# CITY OF ALBUQUERQUE

November 14, 2018

**Re: Burger King**  
**5101 Gibson Blvd 87108**  
**Traffic Circulation Layout**  
Engineer's/Architect's Stamp 8-29-18 (L18D084)

**A1.1**  
TCL

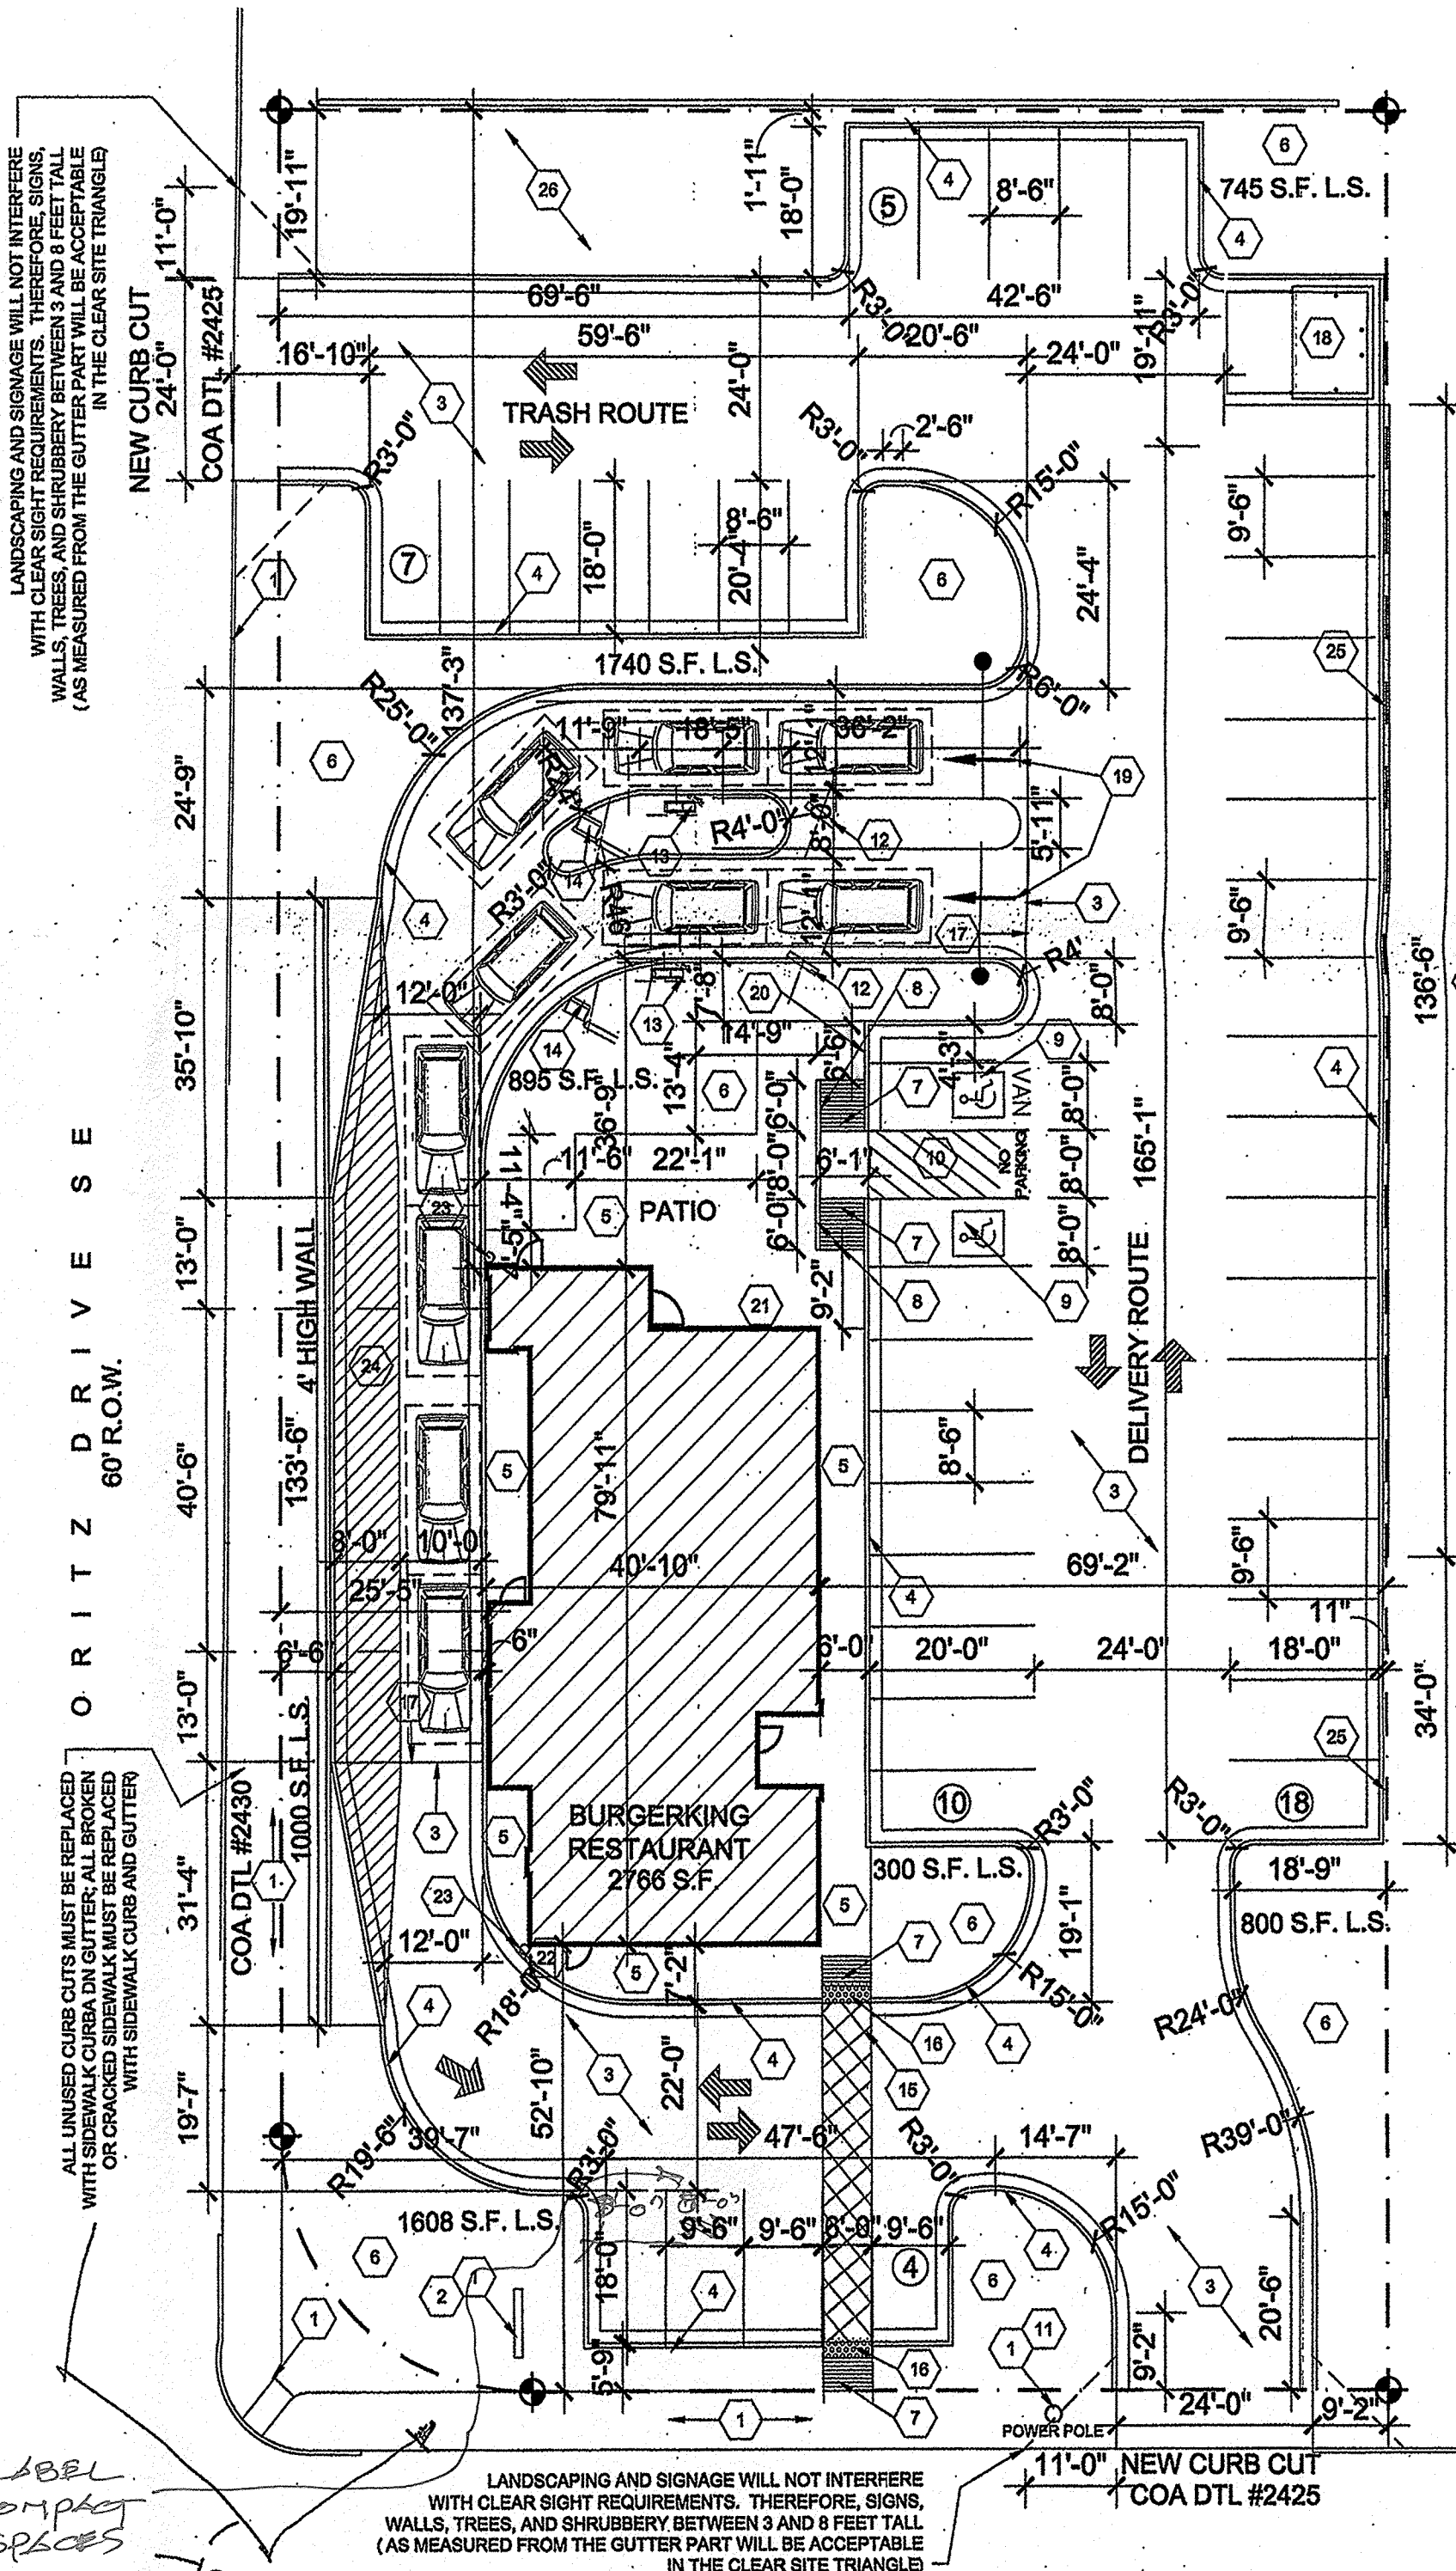
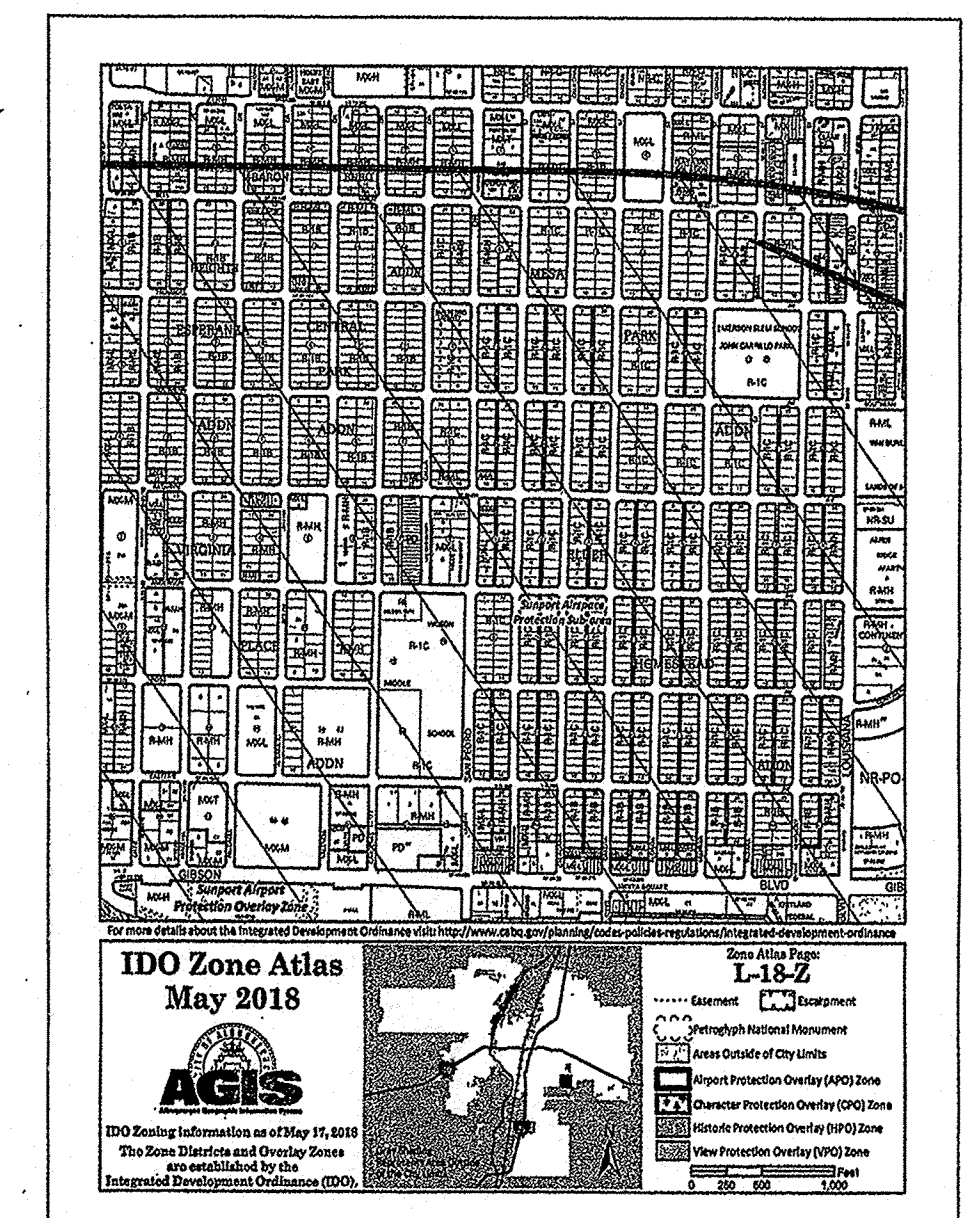
1. The traffic circulation layout must be stamped, signed, and dated by an engineer or architect licensed in the state of New Mexico.
2. Identify all existing access easements and rights of way width dimensions.

3. Identify the right of way width, medians, curb cuts, and street widths on Street(s) Name.
4. Clarify existing property lines and proposed property lines.

5. Design delivery vehicle route needs to be shown.
6. Service vehicle and/or refuse vehicle maneuvering must be contained on-site; provide a copy of refuse approval.

7. Please provide a sight distance exhibit
8. Show the clear sight triangle and add the following note to the plan:  
"Landscaping and signage will not interfere with clear sight requirements. Therefore, signs, walls, trees, and shrubbery between 3 and 8 feet tall (as measured from the gutter pan) will not be acceptable in the clear sight triangle."

9. Please specify the City Standard Drawing Number when applicable.
10. Unused curb cuts must be replaced with sidewalk and curb & gutter. A build note must be provided referring to the appropriate City Standard drawing.

11. Add a note stating "All broken or cracked sidewalk must be replaced with sidewalk and curb & gutter." A build note must be provided referring to the appropriate City Standard drawing.
